Re: Holiday Inn By the Bay, Portland, ME

At your request, we have reviewed the capacity of the existing roof at the anchor locations for a proposed lifeline fall protection system to be installed on the roof on the Holiday Inn building located on Spring Street in Portland, Maine. Our review was based on the information provided on the original construction drawings for the building.

1 ROOF PLAN
 FP1 SCALE: 1/16" = 1'-0"

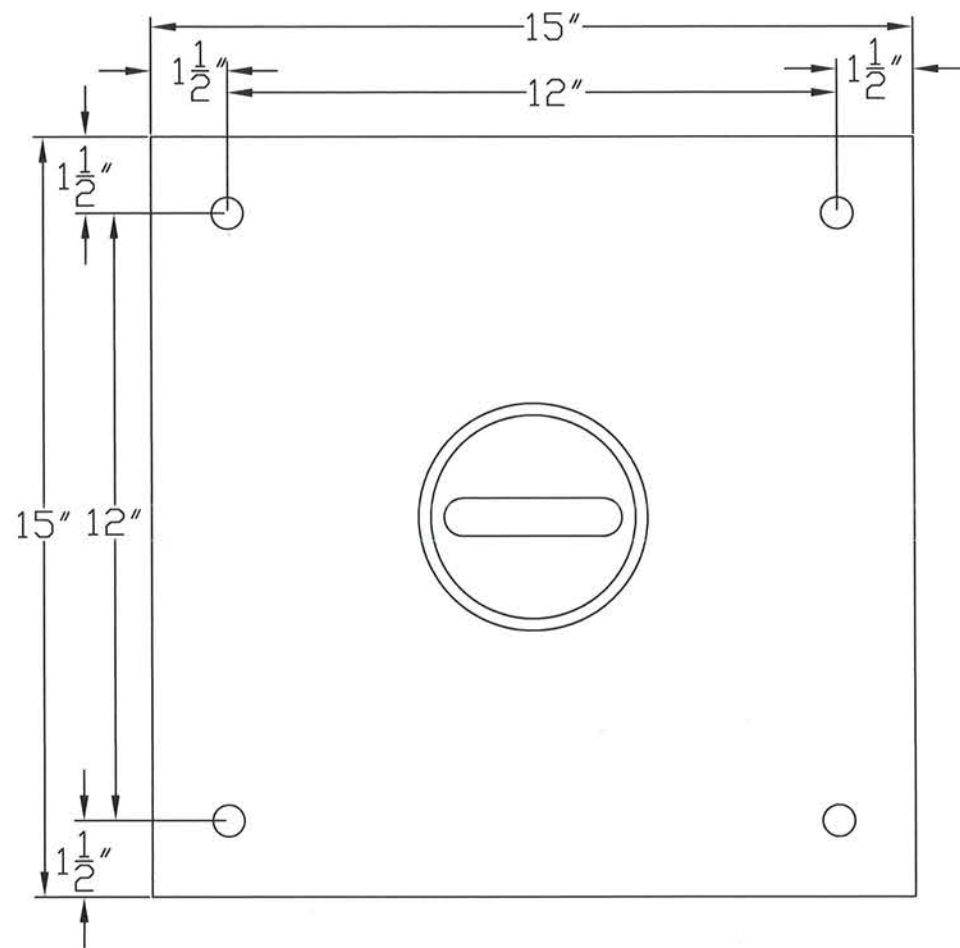
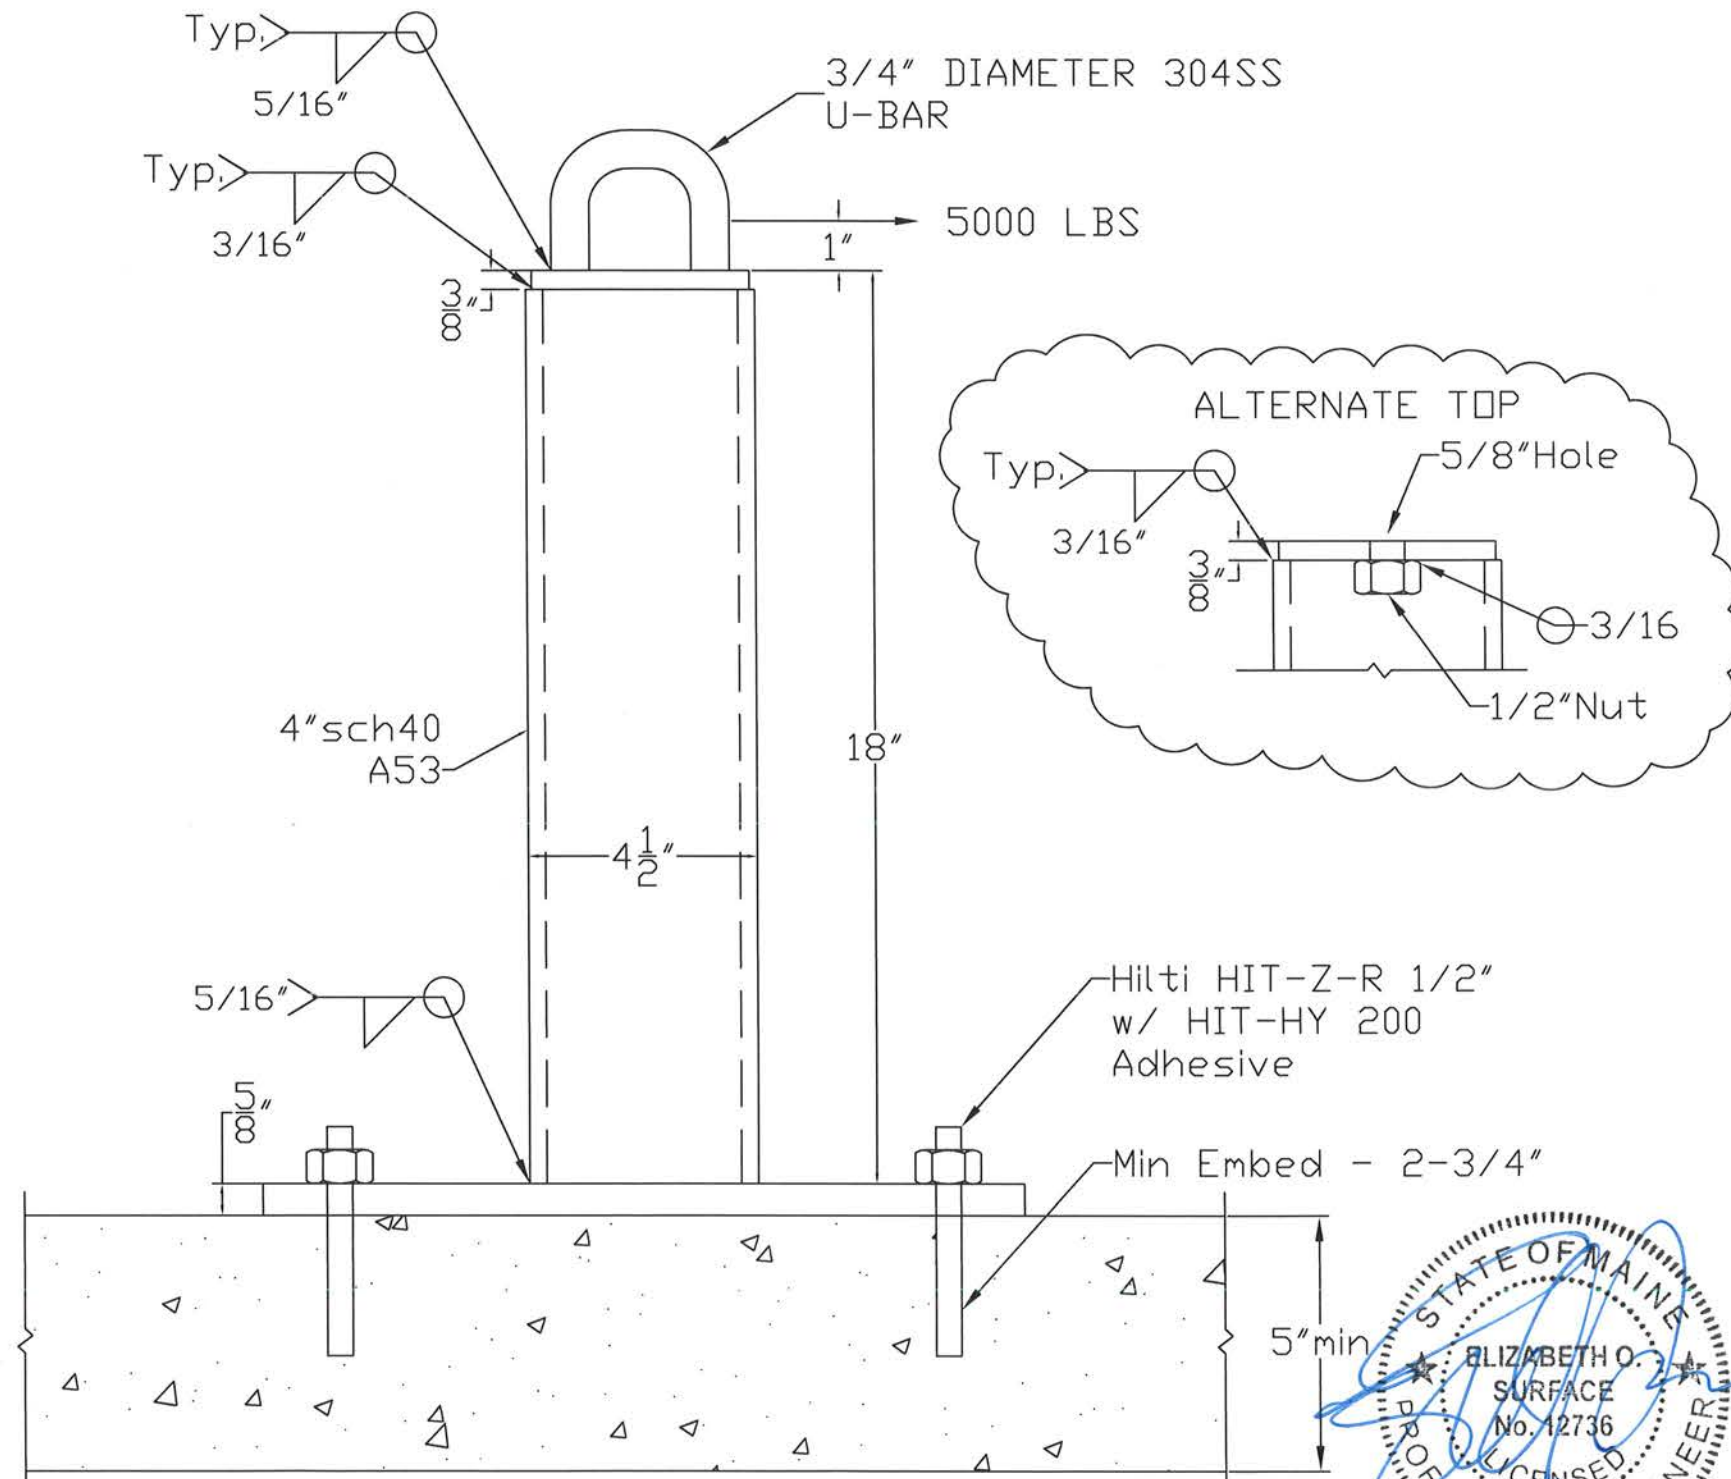
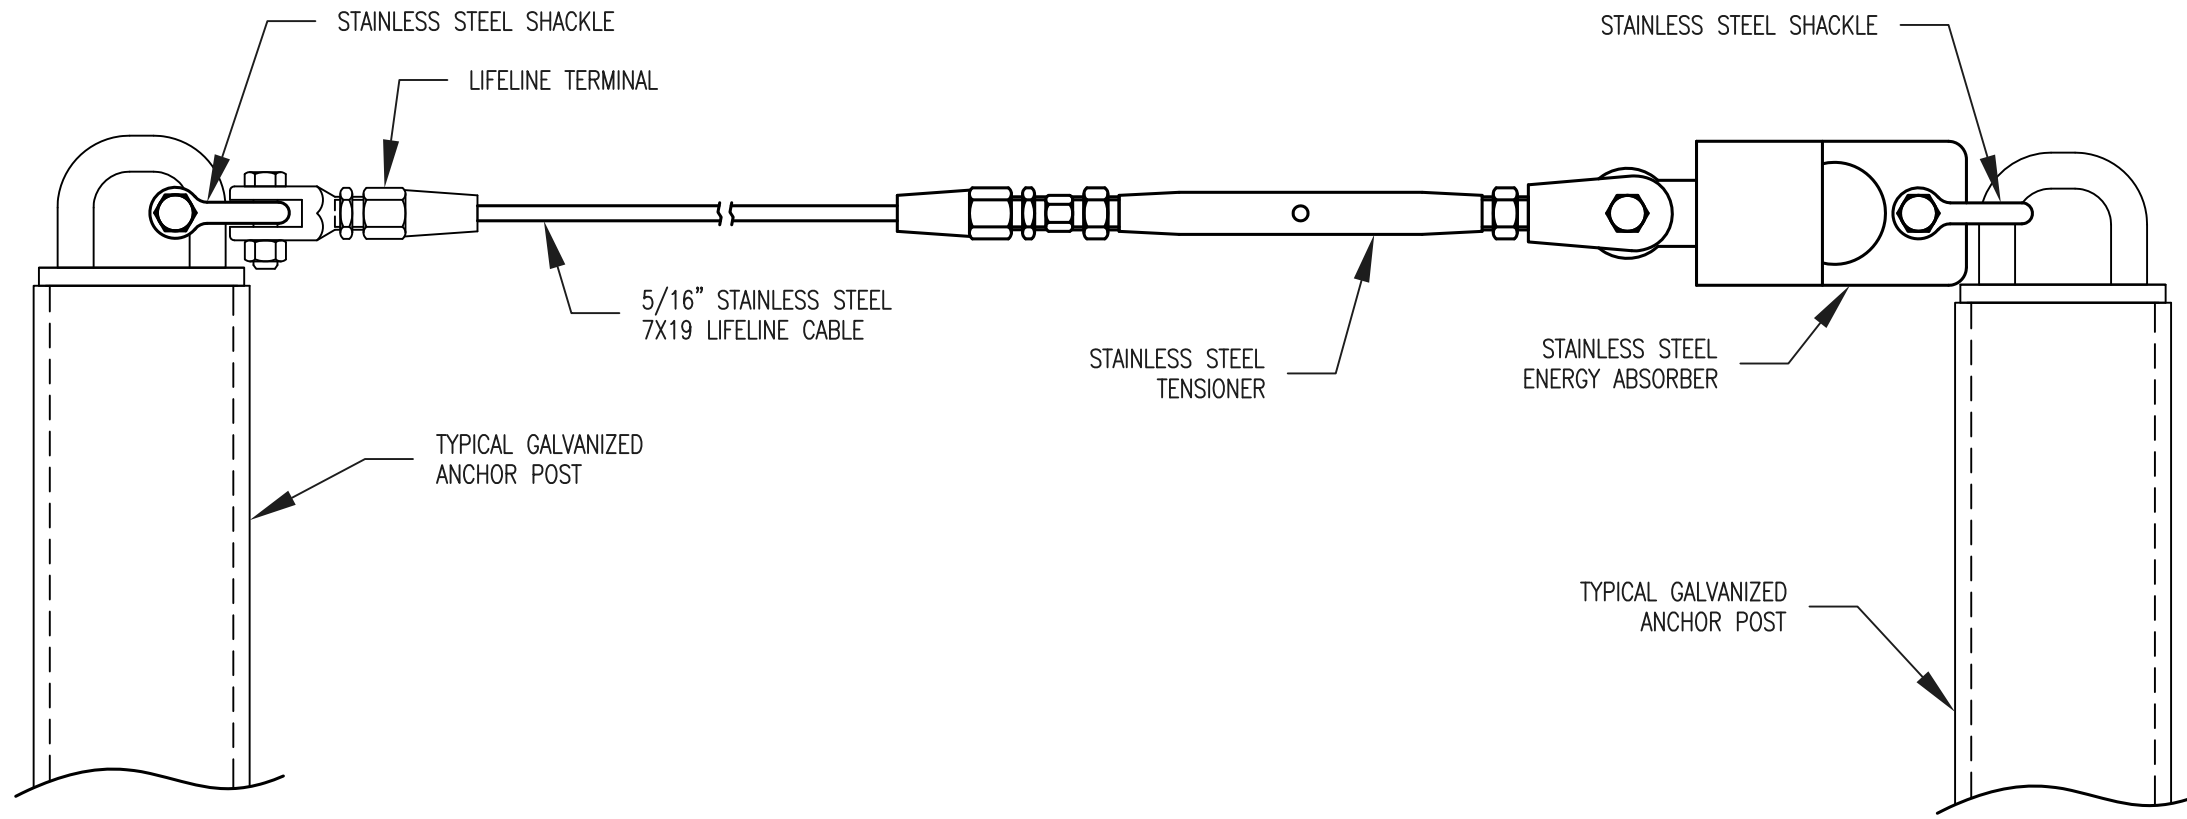
The existing roof consist of the 10-inch-thick reinforced concrete flat slab with a specified concrete compressive strength of 3000 pounds per square inch.

Based on our review of the existing roof construction, the structure is adequate to support the required design loads of the life line fall protection system.

To account for the potential that the anchors may be installed in cracked concrete, the anchor embedment should be increased to a minimum of 3 ¾”.

Prior to the installation of the roof anchor plates, we recommend a licensed professional engineer verify the condition of the concrete substrate
